**Dalswinton Sand and Gravel Quarry SSD 9094**  
**Muswellbrook Shire Council comments on Environmental Impact Statement**

Reference is made to the Environmental Impact Statement (EIS) for the Dalswinton Quarry (the Project) prepared by HDB Town Planning and Design dated November 2021. The proponent for the Project is Rosebrook Sand and Gravel Pty Ltd (the Proponent).

This map presents the predicted Hydraulic Categorisation for the 1% AEP for the existing scenario

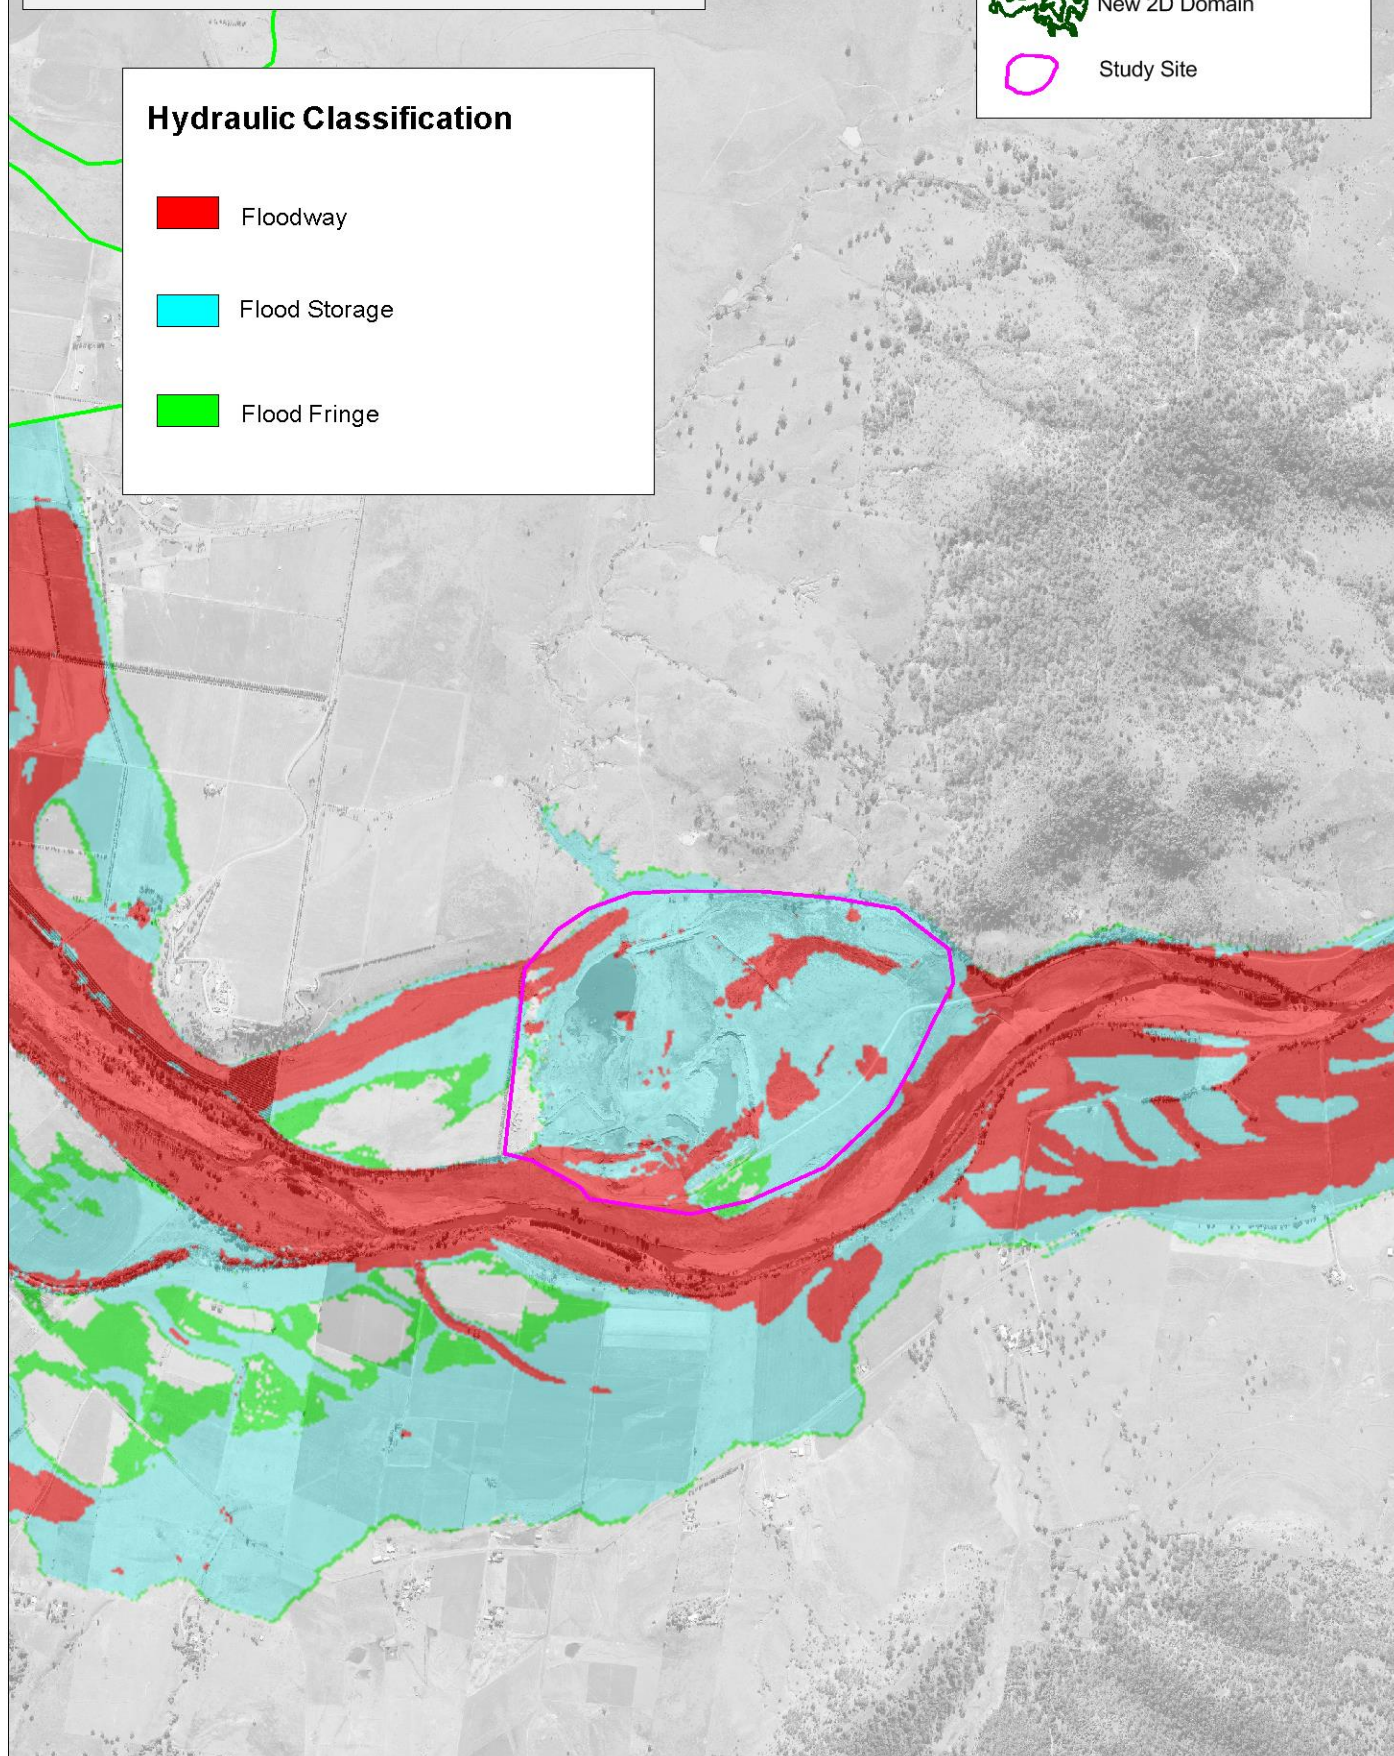
- 6.1 Show on a figure, relevant Project components, the 1% AEP flood level and floodway

**FIGURE 3.1**  
**Existing Water Management System Plan**

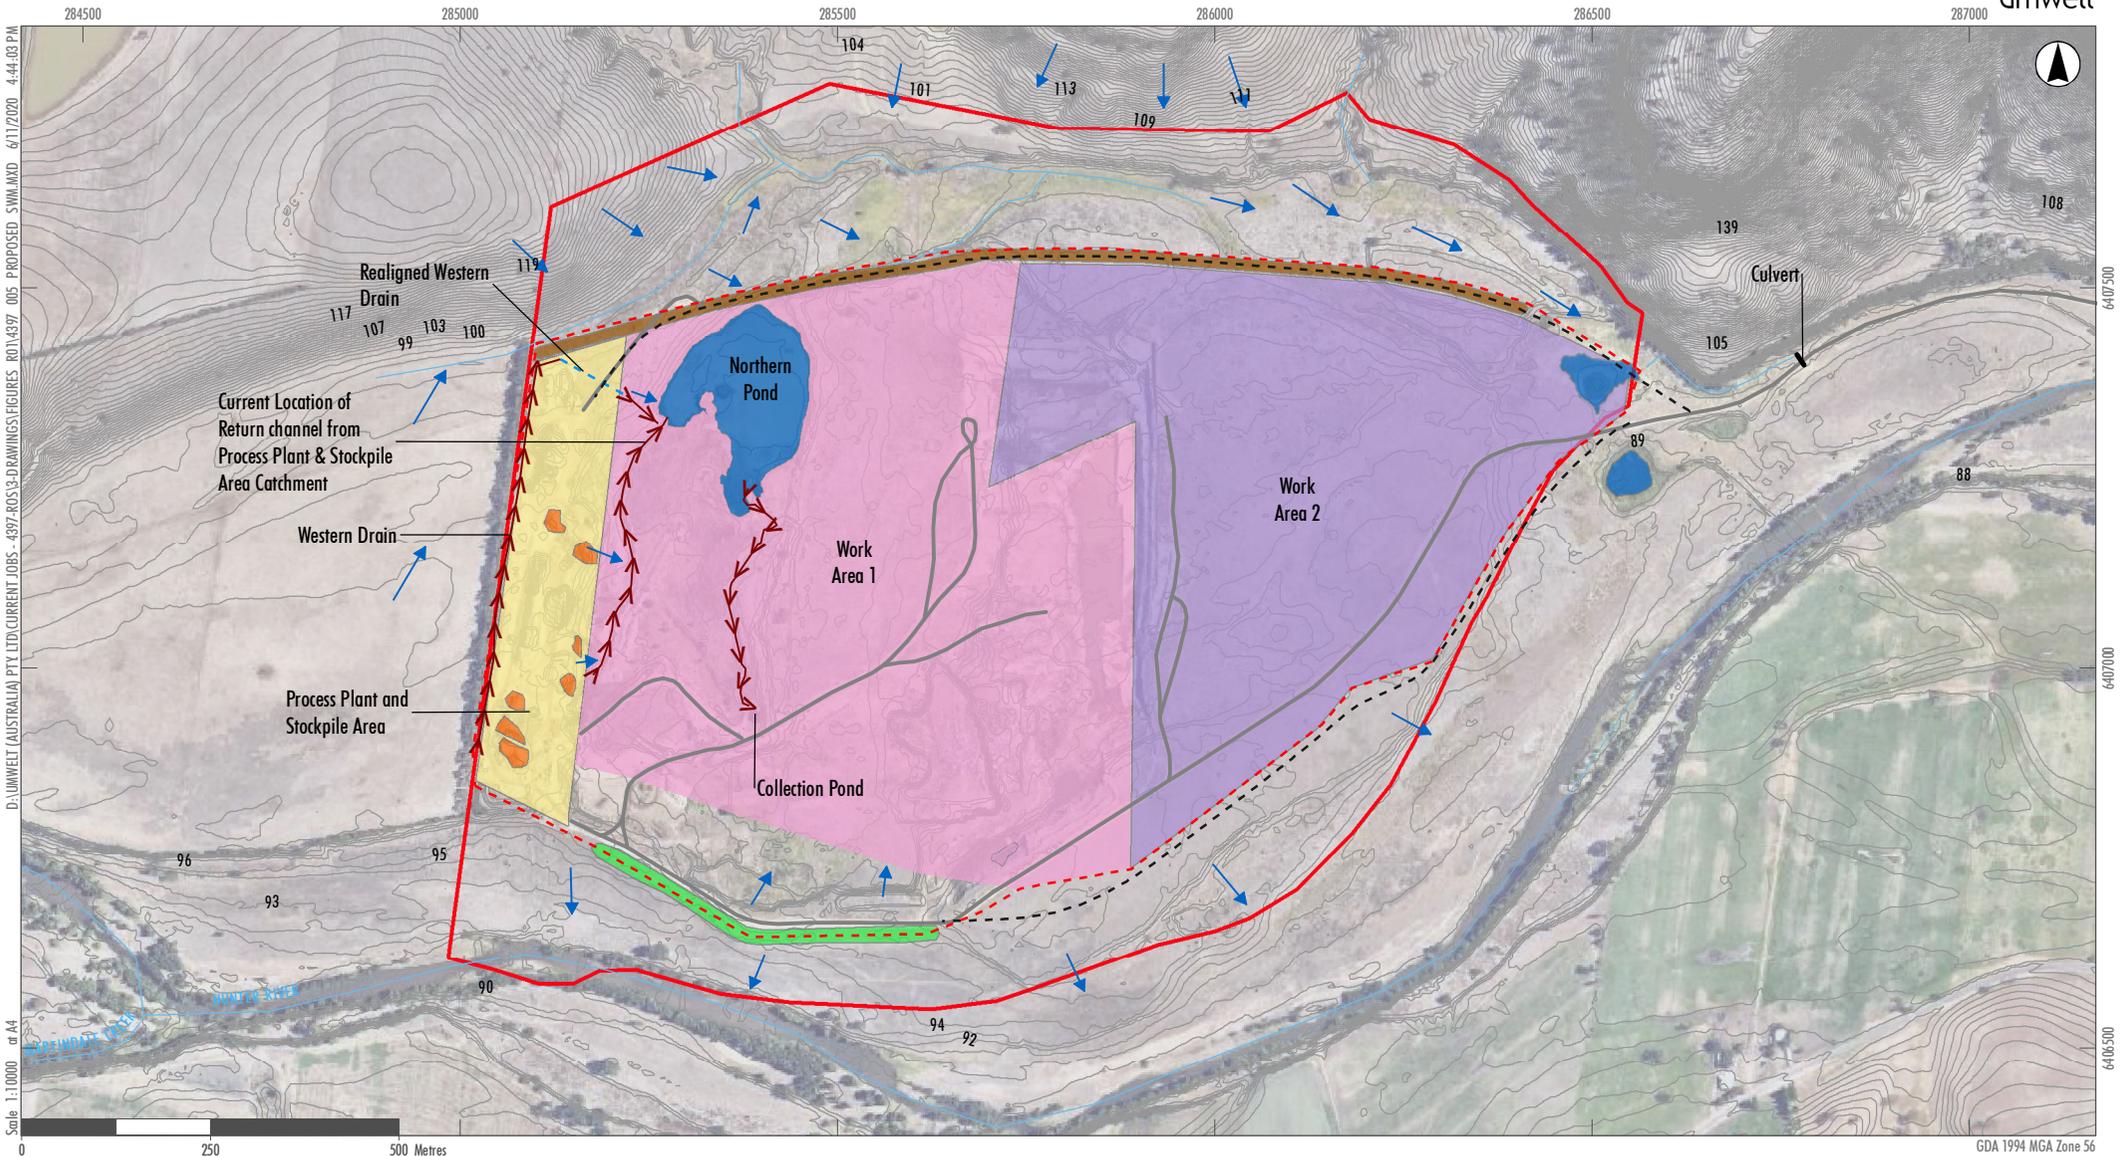
- 9.2 Show the extent of the existing levee and earth bund in comparison to the proposed extension on a figure
- 9.3 Confirm groundwater licencing requirements for the Hunter Unregulated and Alluvial Water Source Water Sharing Plan following the completion of quarrying

Figure 1: General project arrangement and location of sensitive receivers adjacent quarry operations

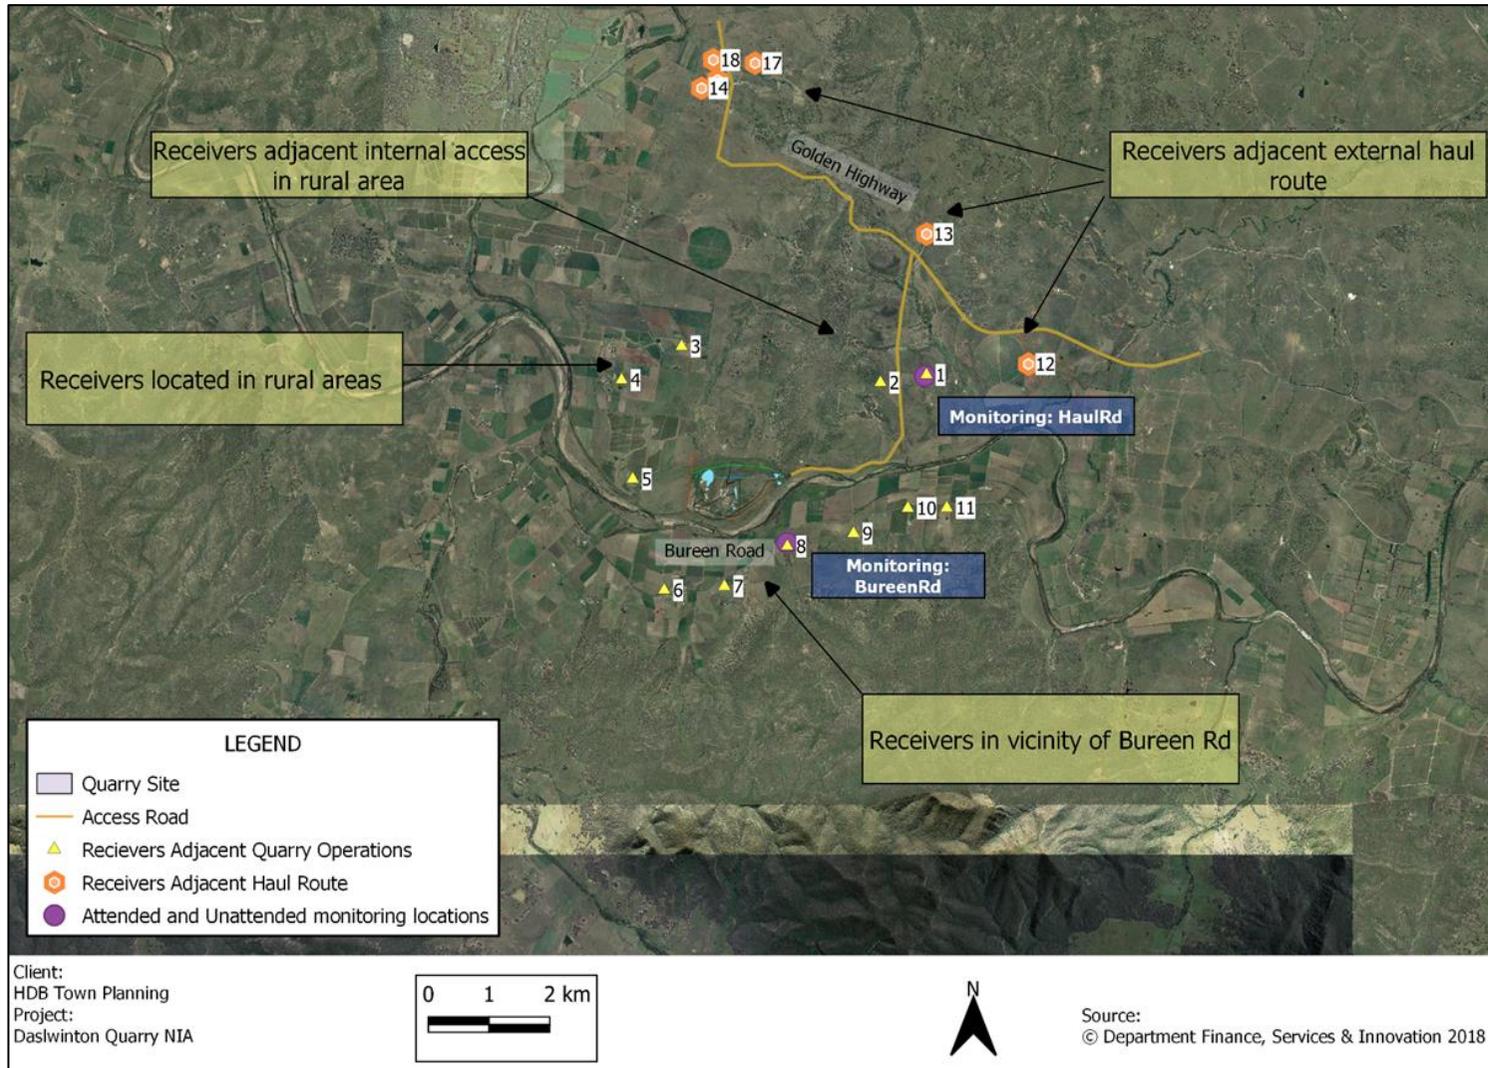
- 10.1 Noise Impact Assessment (NIA) - Confirm why all receivers (specifically IDs 24,15 and 10) shown in Appendix E of the EIS are not included in the NIA
